Vales Point Solar Project

Response to Submissions

Document Title: Response to Submissions Report
 Document No.: Objective Reference D1480486
 Date: 25 May 2018
 Author: Anthony Callen

Figure 5.7 : Proposed Ruttleys Road Access Upgrade

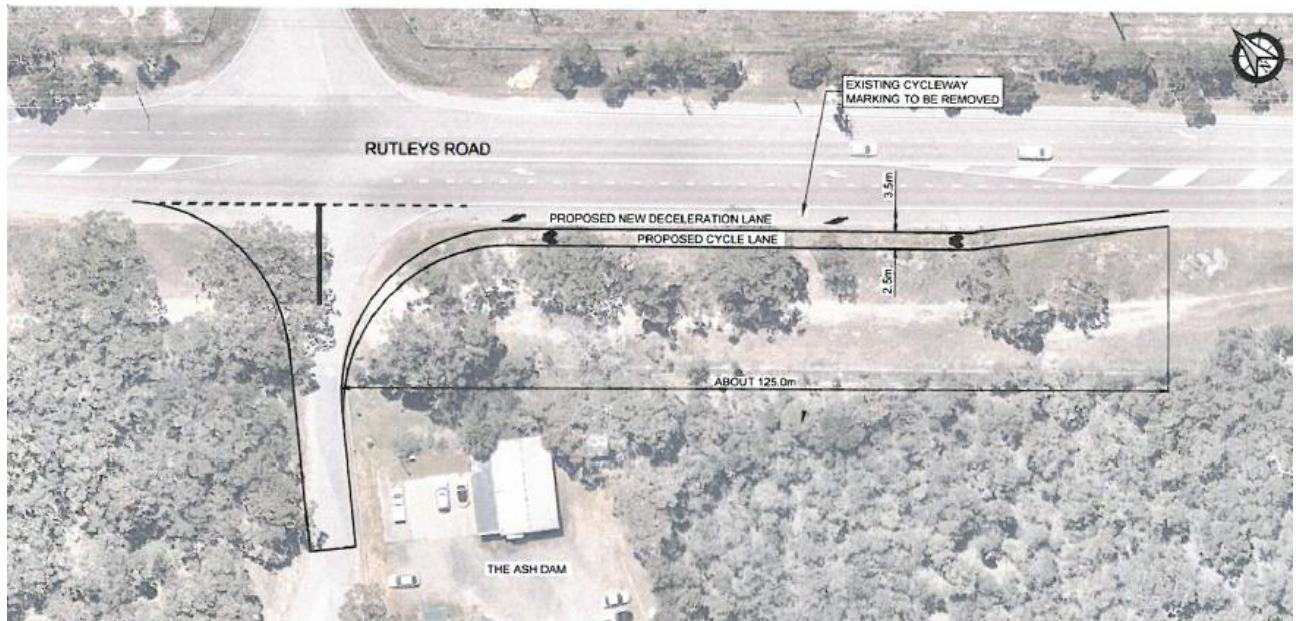
Traffic The information contained in the Traffic Assessment (EIS-Appendix F) does not adequately address the issue of safety of vehicles travelling on Ruttleys Road and potential conflicts with predominantly construction traffic entering and exiting the subject site. Additionally, the suggested traffic volumes for Ruttleys Road (6000 vehicles/day) are approx. 30% below Council's indicative traffic volumes. The road safety assessment appears to be an assessment of RMS crash data and not an assessment of crash risk which would be anticipated for a formal road safety assessment. Additionally, RMS has been in contact with Council concerning the safety performance of the existing access off the Pacific Highway into the development site. We trust the RMS will raise this issue as part of their submission. A formal road safety assessment should be undertaken to ensure the safety of all vehicles travelling along Ruttleys Road.	A formal road safety assessment has been completed for the proposed upgrade to the Ruttleys Road site entrance and is included in Appendix D. The recommendations from the safety assessment will be incorporated in the upgrade works application under Section 138 of the Roads Act (1993) to be developed in consultation with the Central Coast Council. The 6000 vehicles per day figure for Ruttleys Road was an estimate based on peak hour traffic being 10% of the daily traffic volumes. The figure was intended to give context for the road traffic volume but was not used for any of the analysis or modelling completed in the EIS traffic assessment. The recommendations and mitigation measures from the traffic study remain unchanged. It is also noted that the proposal to upgrade the Pacific Highway site entrance has been opposed by Roads and Maritime Services and consequently removed from the project scope.

Issue	Identified Safety Deficiency	Risk Score	Proponents Comments
1.	Laden trucks leaving the ash dam to the west appear not to have enough acceleration length. This may have to the potential for rear-end or side swipe type crashes with approaching vehicles.	High	Existing traffic management protocol requires all trucks exiting the ash dam to turn right (heading east on Ruttleys Rd). The small volume of predominately light vehicles leaving ash dam to the west on Ruttleys Rd can enter the intersection with good visibility and accelerate safely to traffic speed. The Ruttleys Road accident review identifies none of the reported crashes were directly related to the ash dam egress intersection. No further intersection treatment is proposed for vehicles turning west on Ruttleys Road.

2.	Laden trucks leaving the ash dam to the east do not to have an acceleration lane. This may lead to rear-end type crashes	High	The intersection treatment required for trucks turning right from the ash dam and heading east on Ruttleys Rd will be addressed during the detailed design process. It is noted that the majority of trucks leaving the ash dam site are unladen.

3.	The proposed cycle lane directs cyclists into the site rather than to continue through the intersection and there is no defined transition for cyclist when they arrive at the access road. There is the potential for cyclists, believing that they are on a dedicated facility, to be struck by trucks entering the site.	Medium	Detailed design to include the bicycle lane to direct cycle traffic through the intersection.

4.	Due to the proposed high volume of heavy vehicle movements into and out of the site, advance warning signs "Trucks Entering" should be placed on both approaches to the site access.	Comment	A review of existing advanced warning signage for turning vehicles to be completed for both approaches during the design process.

A road safety audit was completed for the proposed upgrade of the Ruttleys Road entrance to the ash dam in response to the Central Coast Council submission and is included in Appendix D. The audit identified some road safety deficiencies in the preliminary design that the Proponent has provided preliminary comments in Table 7.1.

The configuration of the proposed modification for the Ruttleys Road ash dam entrance will be addressed in the design process in consultation with the Central Coast Council under a s138 application. This commitment is to be included as an additional mitigation measure for traffic in Table 6.1 of the EIS.

Issue	Mitigation Measures
Transport	The project includes proposed upgrades to both to the existing Ruttleys Road entrance intersections to improve vehicle access safety. Alternative measures are available and would be implemented should the intersection upgrades not be agreed in time for the construction of the project. The works and mitigation measures proposed include: • A construction traffic and access management plan should be developed and implemented for the project and include a driver code of conduct; and • Upgrade access to the site from the Pacific Highway in consultation with Roads and Maritime Services to include a short left turn lane prior to use of this access associated with the project; and • Upgrade site access from Ruttleys Road under s138 application in consultation with Central Coast Council to improve access and egress efficiency in a manner that does not reduce road safety. Intersection design to consider recommendations from the completed Intersection Road Safety Audit.
